Council Correspondence and Meeting Minutes

Preferred Project Application - MP06-0243 (DA07/0589) for 152 freehold residential subdivision (providing for attached and detached dwellings) and future development lot at Lot 9 DP 1039569, Fraser Drive Tweed Heads South

Attachment – Council Officers Comments

FIGURE No.DA 20
POST DEVELOPMENT
STORMWATER NETWORK

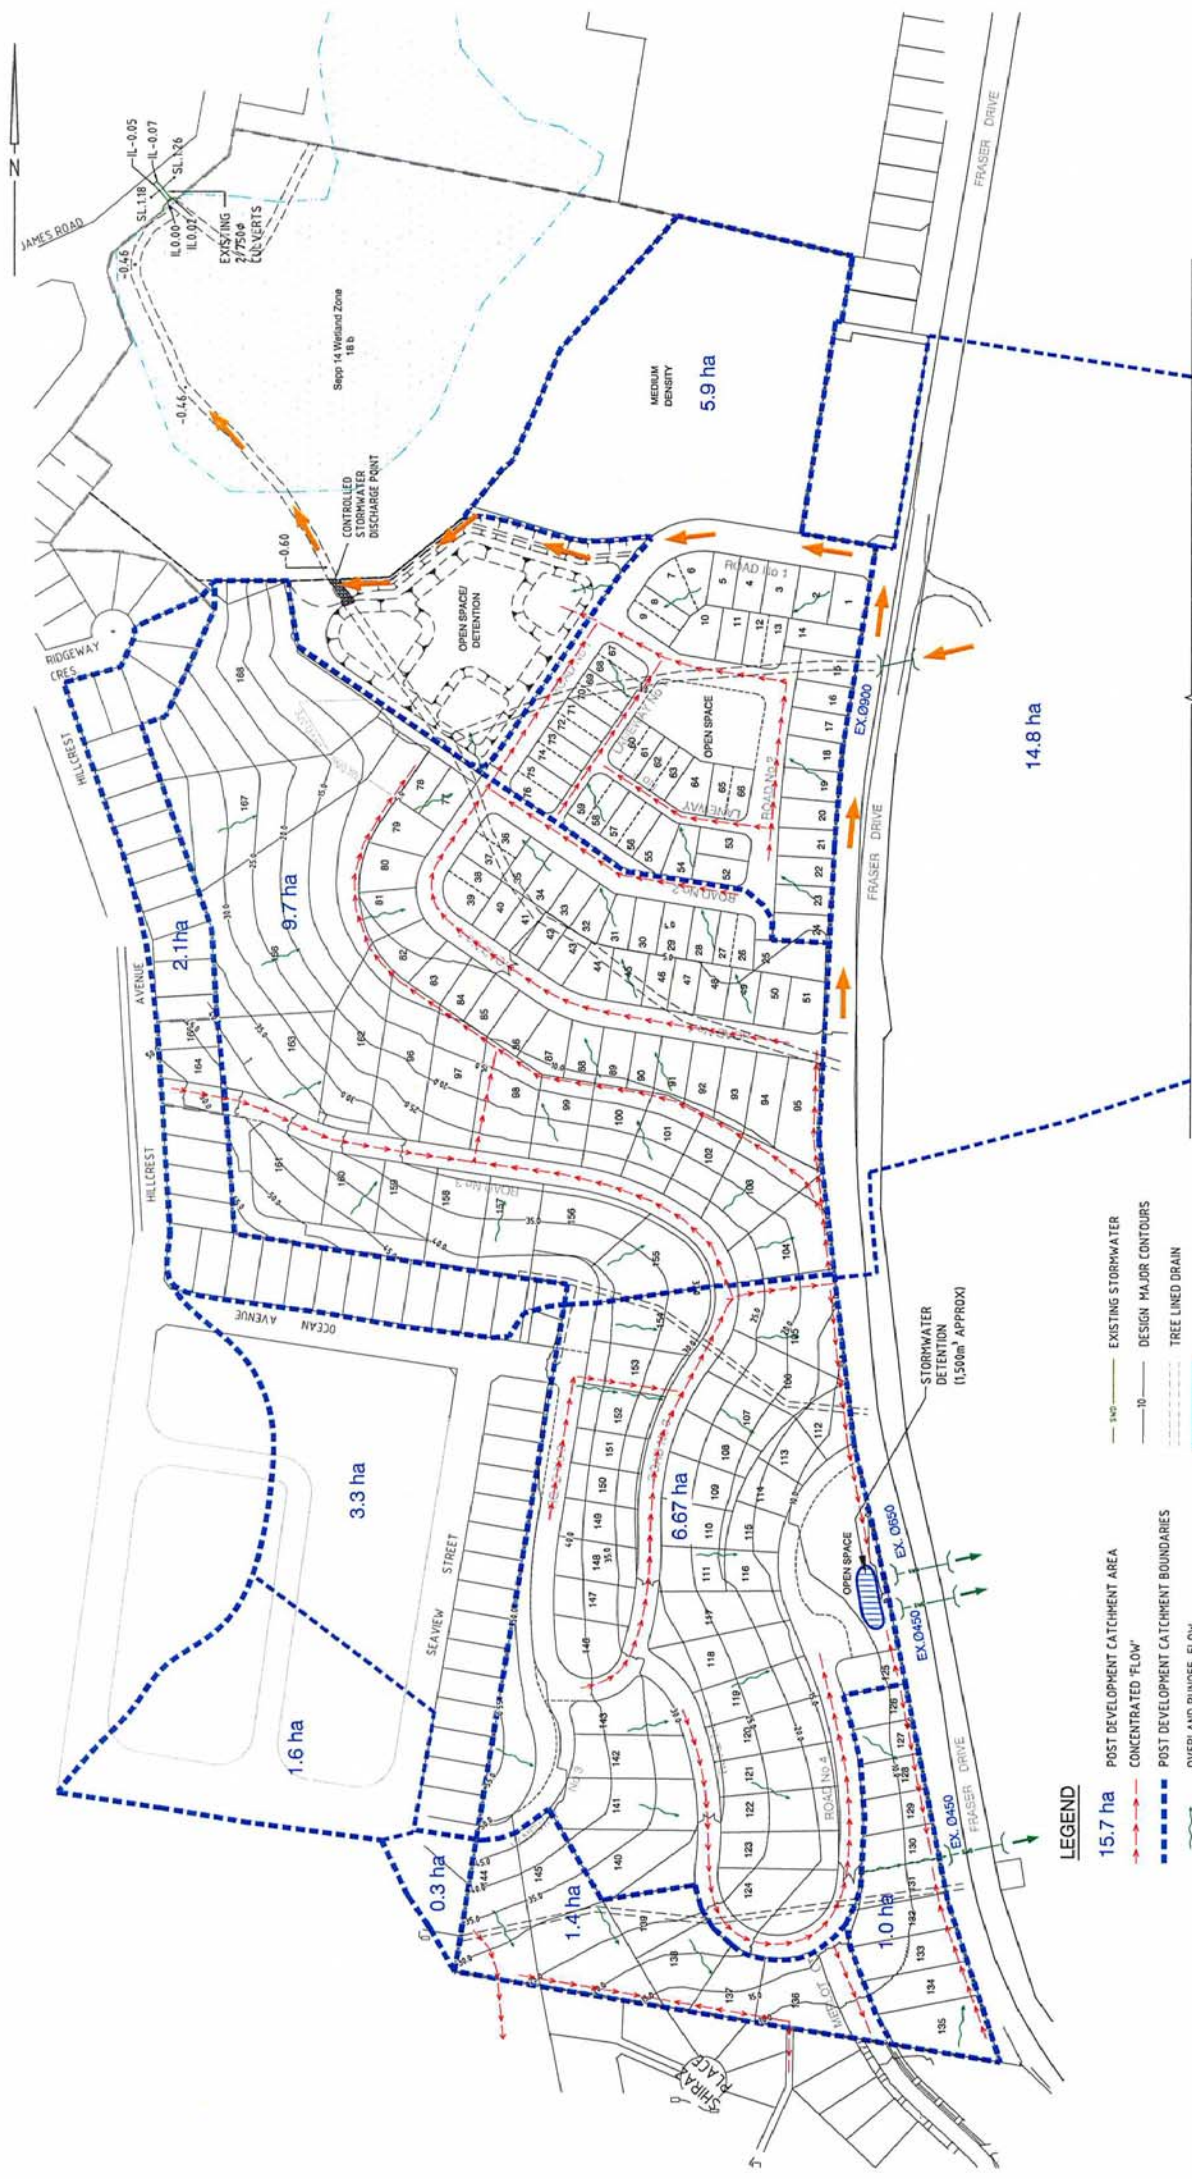
site would exceed 10% slope in the absence of the wall.	
STORMWATER ISSUES		
27. Provide design confirmation that the 3 cell 1500mm diameter piped system is adequate to cater for ARI 100 year stormwater runoff from a future urbanised catchment east of Fraser Drive, without resulting in flooding in Fraser Drive. Preliminary design details of Q100 inlet structures shall also be provided.	This piped system has been modelled in PC Drain. Any head loss that may occur through the bends has been accounted for in this modelling. Our developer can not impose construction requirements onto another landowner. If Council want the culverts to cross Fraser Drive, then the existing landowners future access and current drive way entrance would have to be moved and the existing drainage path 900 dia culvert would have to be re-routed. It is not reasonable to impose conditions which we can not lawfully impose on another landowner. It is also unreasonable to impose the requirement for the allowance of flows from a developed upstream catchment. Given the requirement for our site to have on site detention to maintain existing peak flows, it should be the responsibility of the upstream property owners to also maintain existing peak flows from their site. Should this condition remain it would be necessary for the applicant to request stormwater headworks credits for any additional infrastructure and loss of land due to allowing for flows greater than the property currently accepts.	The open channel within a Council easement that traverses the development site currently provides the capability to discharge all flows (under current and future conditions) from the eastern catchment through the site to the SEPP 14 wetland. As the applicant is requesting that Council relinquish this service, equivalent drainage must be provided, and must be capable of catering for the potential increase in runoff from a fully urbanised eastern catchment (as the zoning currently permits). FURTHER INFORMATION REQUIRED.

28. Amend the design of the 3 cell 1500mm diameter piped system to provide a straighter alignment (eliminating 90 degree bends) between the catchment east of Fraser Drive and the bypass channel for the treatment/detention ponds in Part A of the subdivision, to maximise inlet capacity and minimise the chance of blockage. Further investigation of solutions to the potential conflict between stormwater services and the existing water main in Fraser Drive shall also be provided, to allow for the relocation of the stormwater inlet to the eastern side of Fraser Drive to eliminate the existing 900mm culvert.	This issue has been addressed in Appendix B. In summary, Council have previously requested that this site and the site across the road share a common intersection for access to Fraser Drive. The entrance to this site was placed in accordance with Council's recommendation. As the stormwater pipes are located under the roadway due to their size, it makes it impossible to align the stormwater line perpendicular to Fraser Drive without affecting opposite properties driveway access, or possible future development. Even placing pipes under Fraser Drive at a 45 degree angle to the road would require earthworks in the opposite property to change the existing overland flowpath, and re-grade it to the new culvert crossing.	Limitations on works on adjoining land are acknowledged. The proposed arrangement of the 3 cell 1500mm diameter pipes is satisfactory to Council, provided the applicant can demonstrate that there is an alternative failsafe surcharge flow path from Fraser Drive to the SEPP14 wetland. This is currently available in the form of an open channel within an easement benefitting Council, and this will not be relinquished unless a satisfactory alternative system is in place. This flow path is necessary to prevent flooding impacts in Fraser Drive and adjoining low lying properties. FURTHER INFORMATION REQUIRED.

I apologise for the delay in getting this to you, however, we would like to resolve this issue with you ASAP. Could you please advise if Tweed Council are thus generally satisfied with the provision of open space within the Part B section of proposed subdivision and management of bushfire.

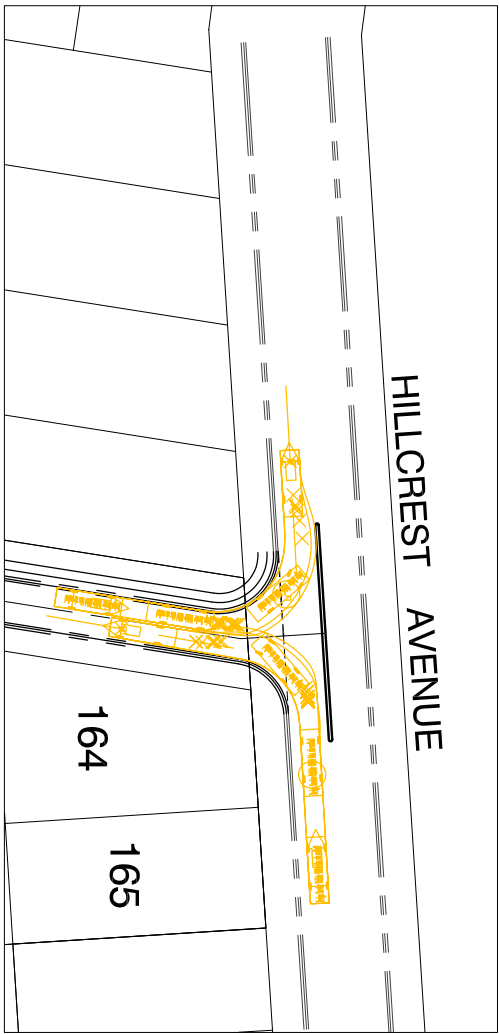
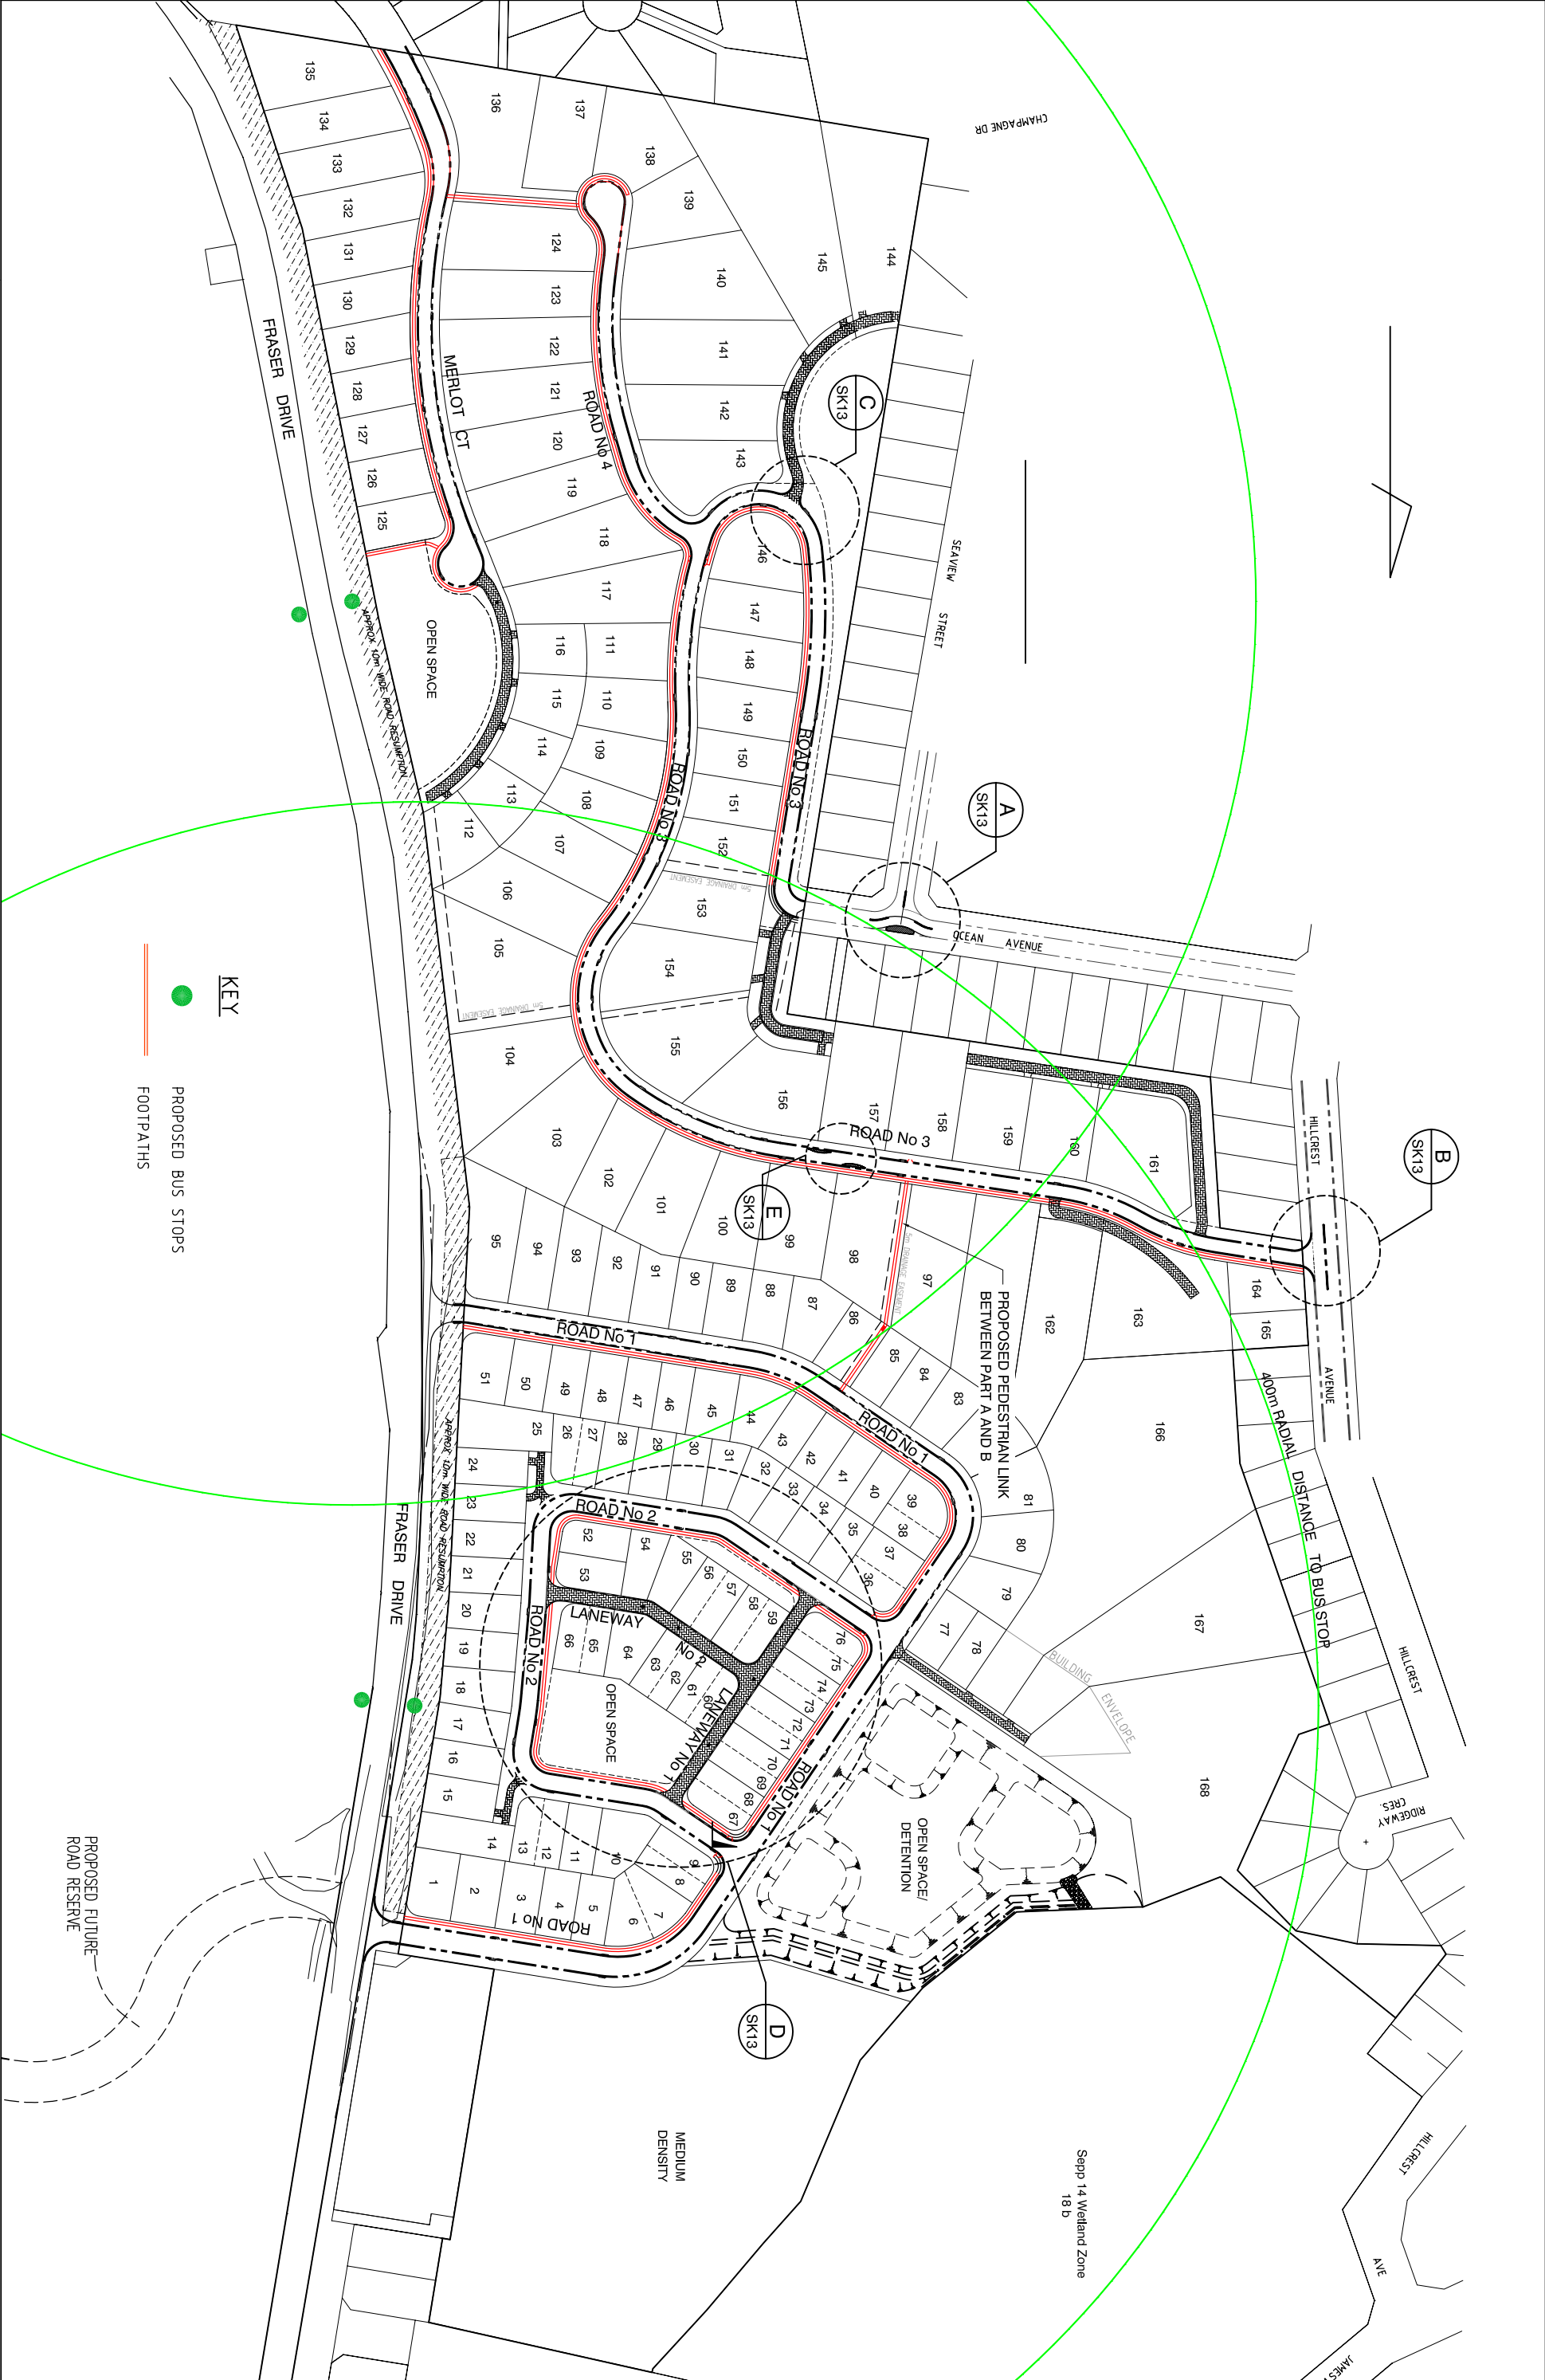
- The plan of subdivision is to extend lot boundaries to facilitate a right of carriageway traversing through the lots.
- The proposed right of carriageways or proposed garbage collection points located at the start of the right of way does not address the manoeuvrability for a garbage truck.
